**Consultation Response from KC,
Highways Development Management**

2025/92161 Land adj, 17, Whitehall Road West, Birkenshaw, BD11 2LS

Discharge of details reserved by conditions 4-8 (intrusive investigations), 11 (Remediation Strategy and Verification Report), 12 (CEMP), 13 (noise), 14 (Arboricultural Method Statement), 15 (CMP), 16 (highway), 17 (visibility), 18 (Safety Audit), 19 (estate streets), 20 (waste collection), 21 (surface water attenuation), 24 (bin storage), 25 (bicycle storage), 26 (drainage), 28 (drainage), 29 (CEMP: Biodiversity),-30 (landscape), 34 (solar panel array), 35 (materials), 38 (boundary treatments) on previous permission 2024/92281 for erection of 23 dwellings

Date Responded:20-8-2025.

Client: ORION HOMES
Status: FOR APPROVAL
Scale: 1:250
Size: A2 - 594 x 420 | Drawn: CT | Chkd: BR | Appvd: JP
Project: WHITEHALL ROAD, BIRKENSRAW
Title: KERBING DETAILS

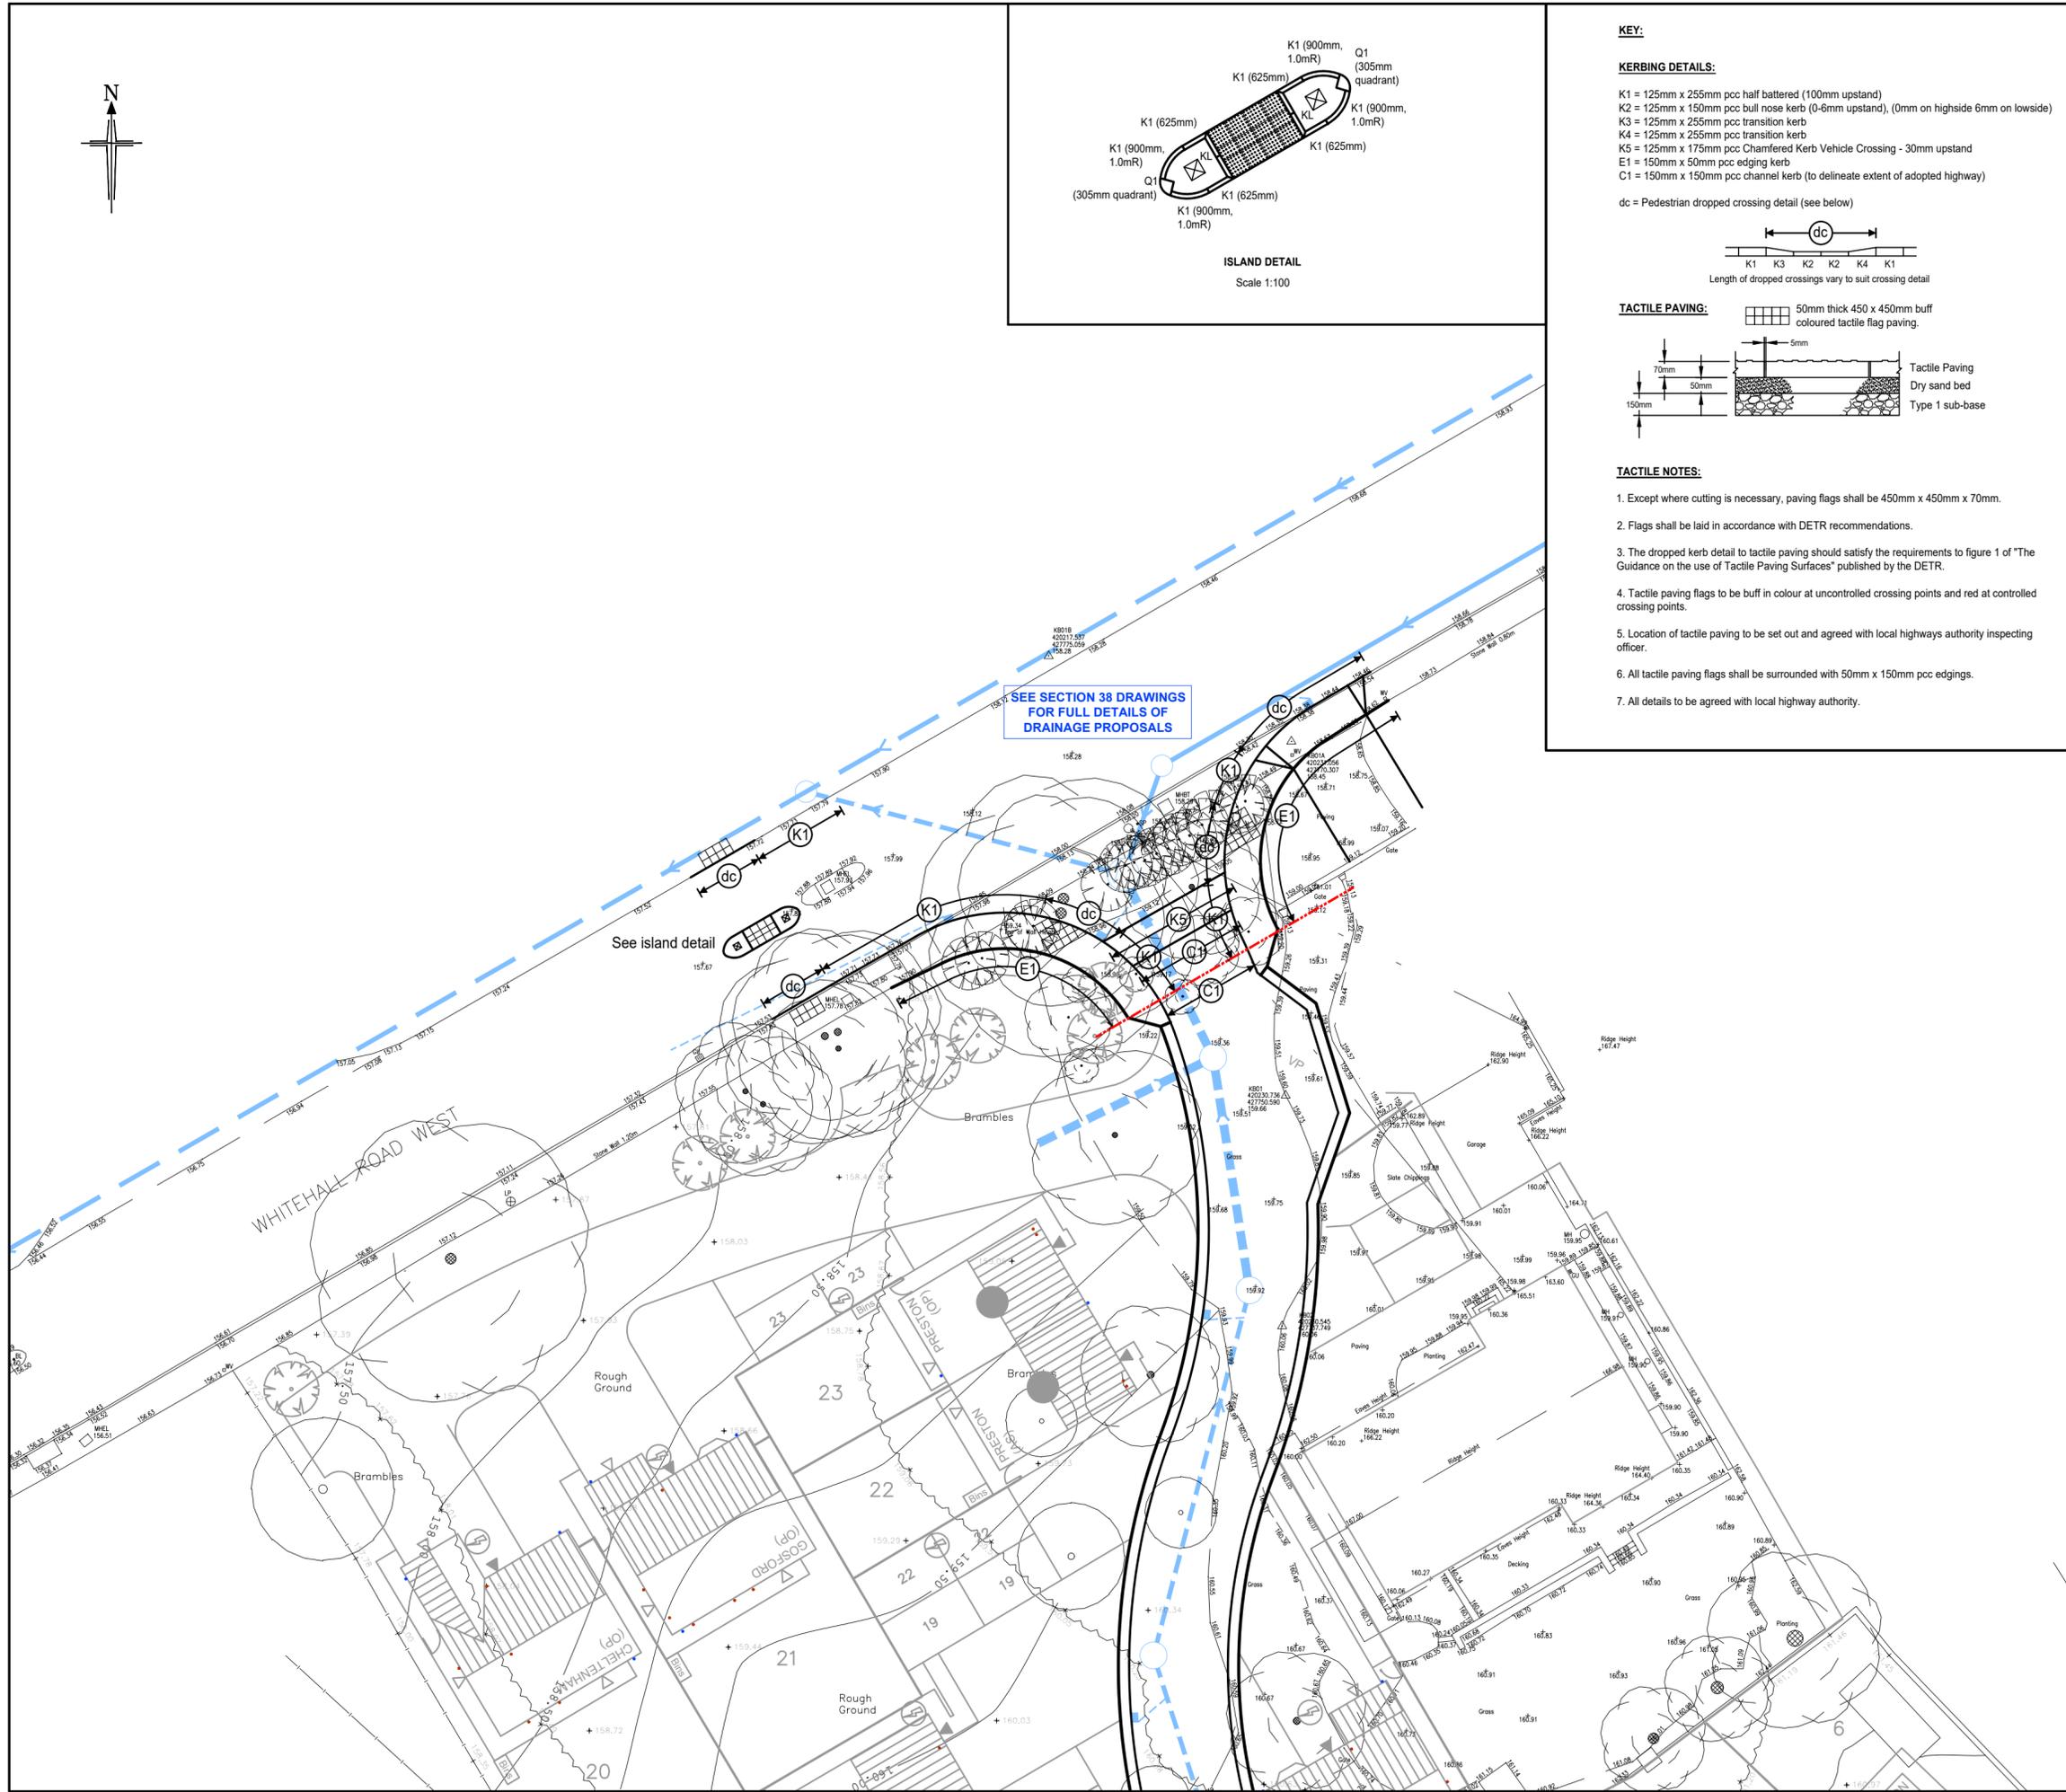
This condition will require the formal approval of the Councils 278 Engineer. The 278 Engineer has requested amendments to the design of the proposed access from Bradford Road and this condition cannot therefore be discharged.
